Rezoning Transportation Analysis

Petition Number: #2022-125

Date	Description
12-29-22	First Review (TM)
1-27-23	Second Review (DR)

RZ-2

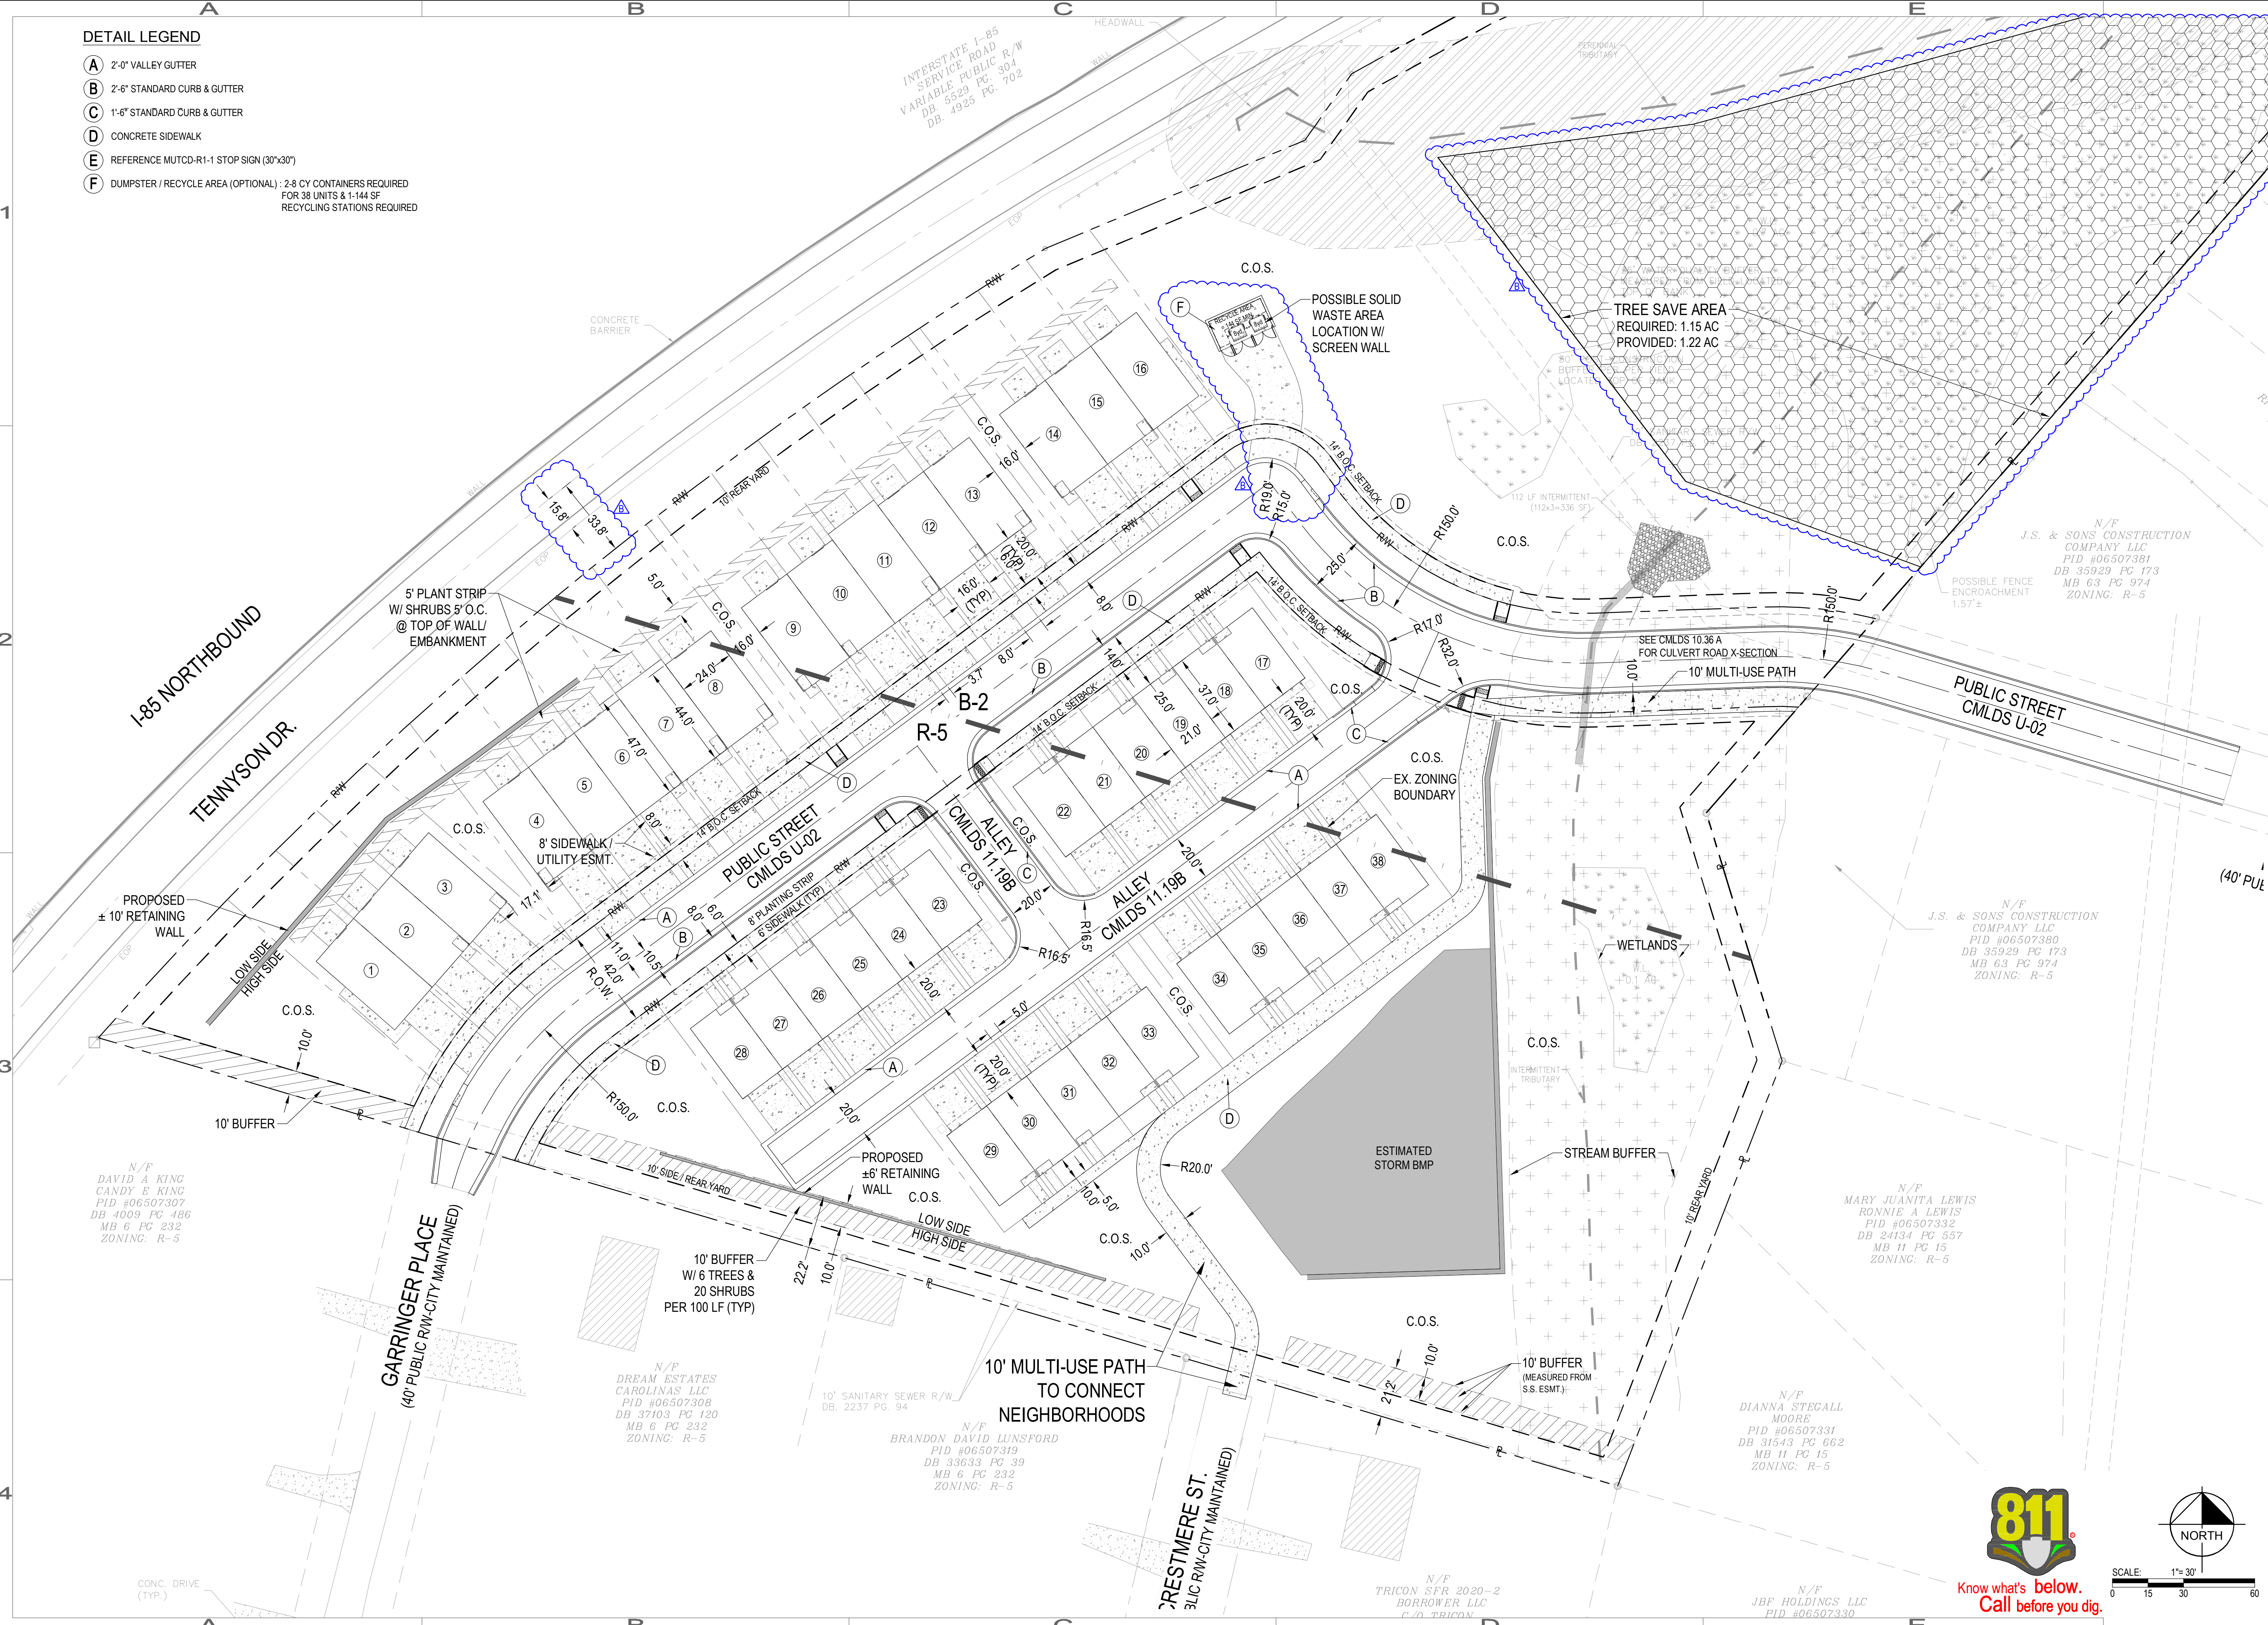
6. Revise site plan and conditional note(s) to meet CDOT standards for public roadway geometry. Label each roadway as public or private.

Clarifying Comment 01-27-23: CDOT will not accept current design. Revise roadway to remove 90 degree turn and satisfy CDOT standards for public roadway geometry. Remove crosswalk, stop bars, and stop signs.

3. Revise site plan and conditional note(s) to commit to dedicate a min of 28-feet of right-of-way from the road centerline along site frontage of Tennyson Drive. The site plan shall label and dimension the right-of-way from the road centerline.

Outstanding Comment From 1-24-23: Add conditional to dedicate a minimum of 28-feet of right-of-way from the roadway centerline along site frontage of Tennyson Drive.
